**MODIFICATION REQUEST:
MP10_0016 MOD 2**

***Scottish Hospital Seniors Housing and
Care Facility***

Environmental Assessment Report
Section 75W of the *Environmental Planning and
Assessment Act 1979*

April 2017

DRAWING TITLE: LEVEL 06 PLAN	
DOCUMENT CONTROL STATUS: PRELIMINARY	
PROJECT NO: 2014063	
DRAWN BY: JPR A	
SCALE: 1:250 @A1	
DRAWING NO: A-X-P-1106	REV: AA
PLOTTED: 17/06/2016

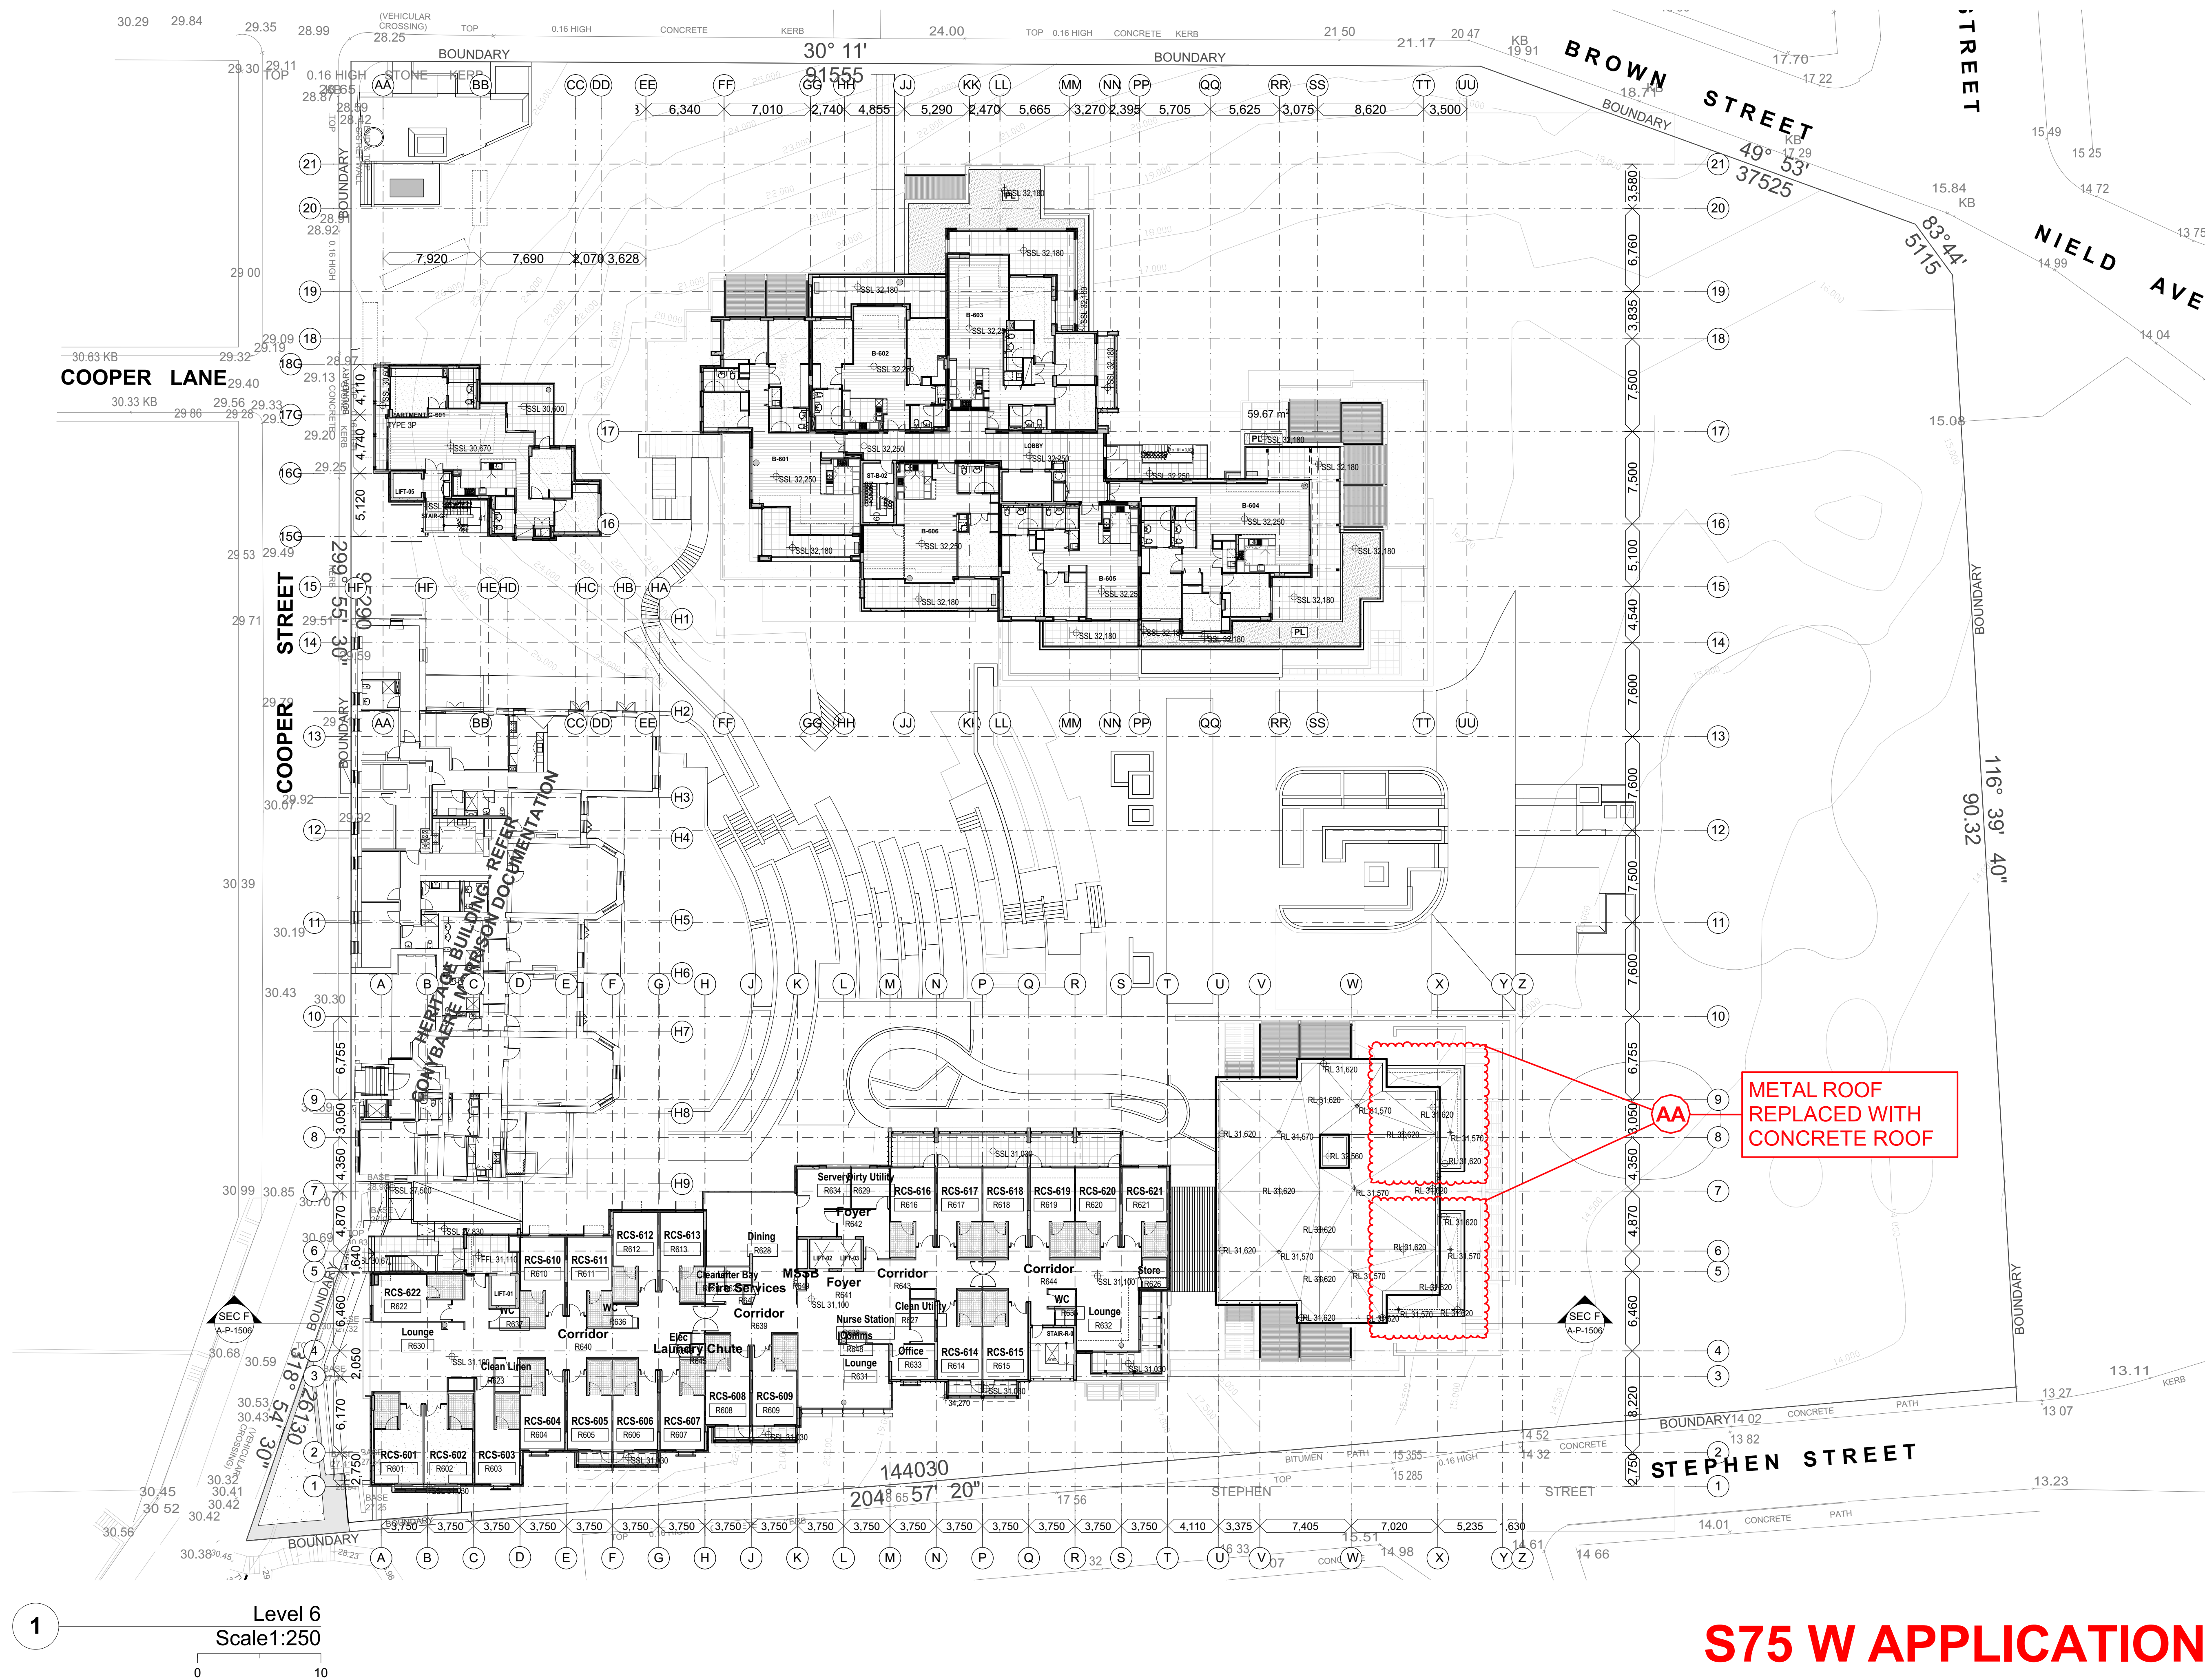
The Proponent proposes to replace the approved metal roof of both the Brown Street ILU and Stephen Street RACF/ILU buildings with a concrete slab (**Figure 11**). The Proponent contends that this change in material will improve the longevity of the structure due to the site's proximity to the salt water of Sydney Harbour, as well as acoustic and thermal performance. It will also ensure ease of access to the roof for maintenance purposes. The return fascias on the building elevations will remain clad in metal in order to maintain the appearance of a metal roof when viewed from the public domain.

The Department accepts the Proponent's justification for the change in roof material. The Department supports this aspect of the proposal as the use of cement will provide greater structural integrity to the roof, and the cladding of the fascias will ensure the buildings retain the appearance of a metal roof when viewed from the public domain.

DRAWING TITLE:
LEVEL 09 - ROOF PLAN - BROWN STREET BUILDING

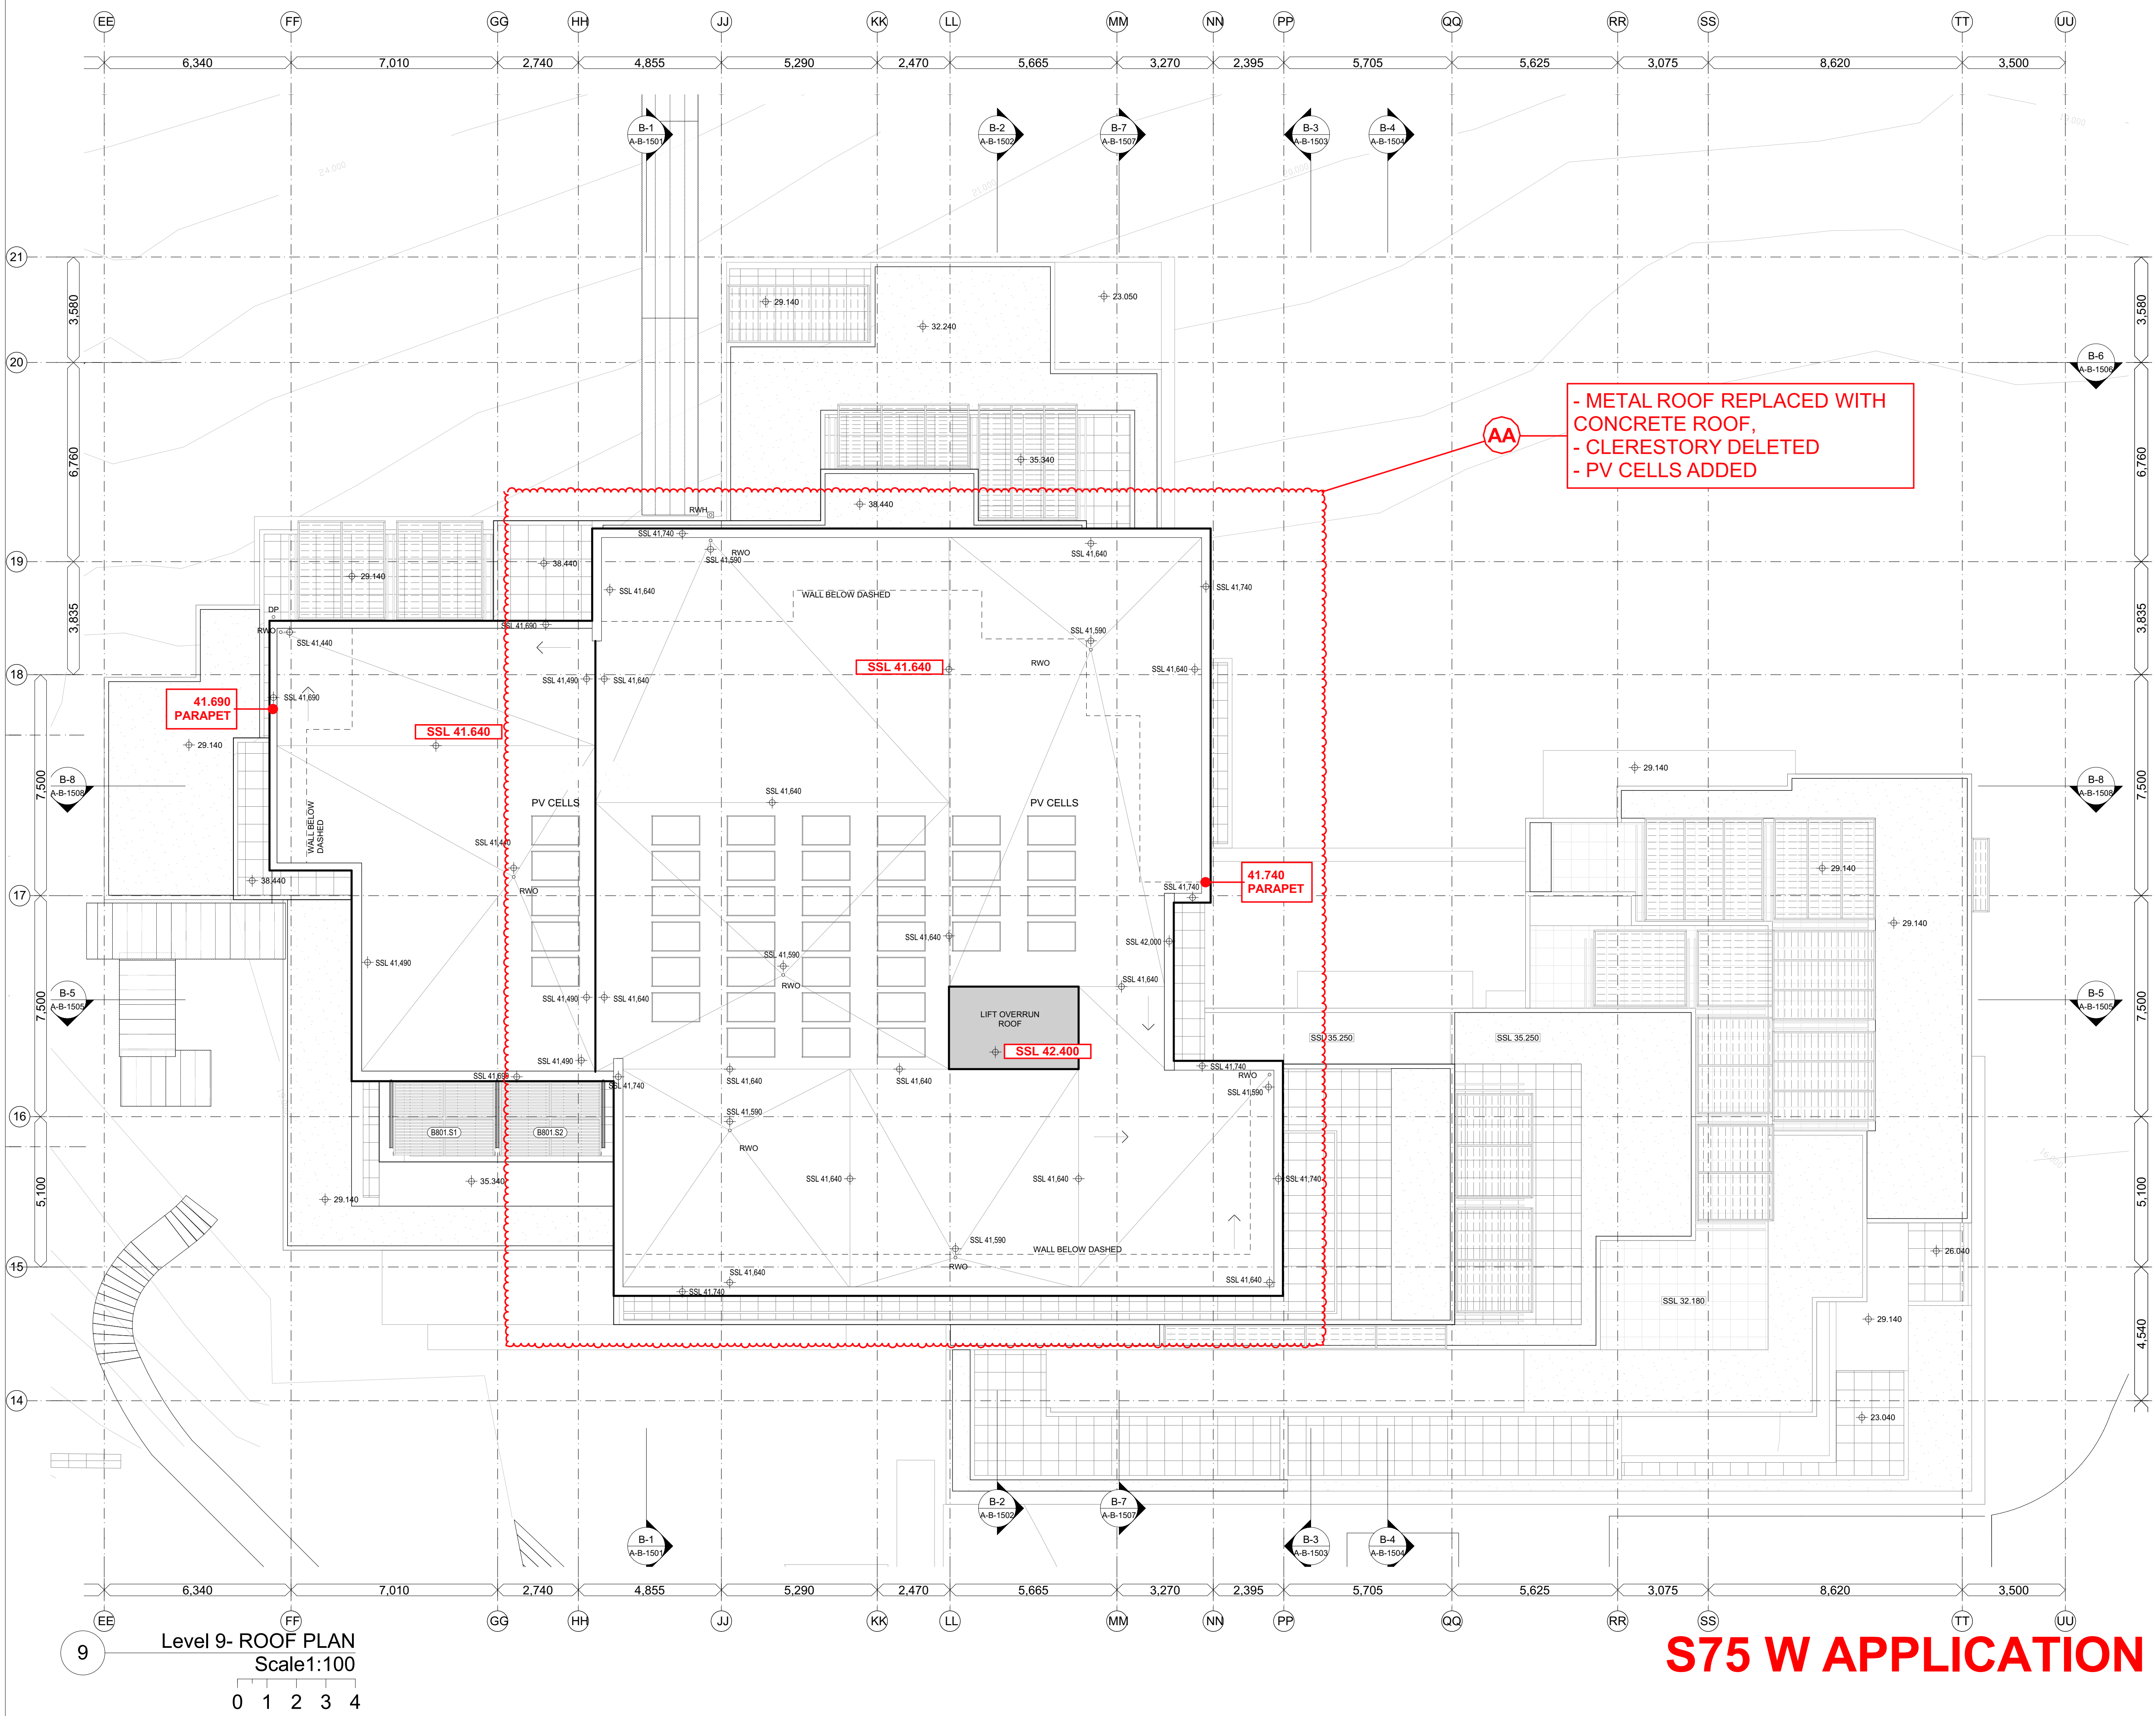
The Proponent is seeking to install photovoltaic cells on the roof of the Brown Street ILU building to achieve BASIX energy efficiency requirements (**Figure 10**).

Public submissions raised concerns that the photovoltaic cells would be visible from the public domain area of the Heritage Conservation Area. In its RtS, the Proponent has submitted an elevation showing that the photovoltaic cells will not be visible from the public domain.

Street RACF Building and deletion of all of the clerestory windows on the Brown Street ILU building (as shown in **Figure 10**).

The Proponent is seeking to remove the clerestory windows as they do not provide any purpose or provide any sunlight benefit to the upper level residences. Deletion of this element would also provide additional thermal and acoustic benefits to the apartments below and reduce maintenance costs for the building.

The Department has reviewed the relevant information and is satisfied that the Proponent has adequately demonstrated that the photovoltaic cells will not be visible from the public domain. Considering that the photovoltaic cells are required to achieve BASIX requirements and will not have any impact to the streetscape, the Department supports its use on the Brown Street ILU roof.

The Department supports the deletion of the clerestory windows and is satisfied that there will be no reduction in the overall design quality of the building.
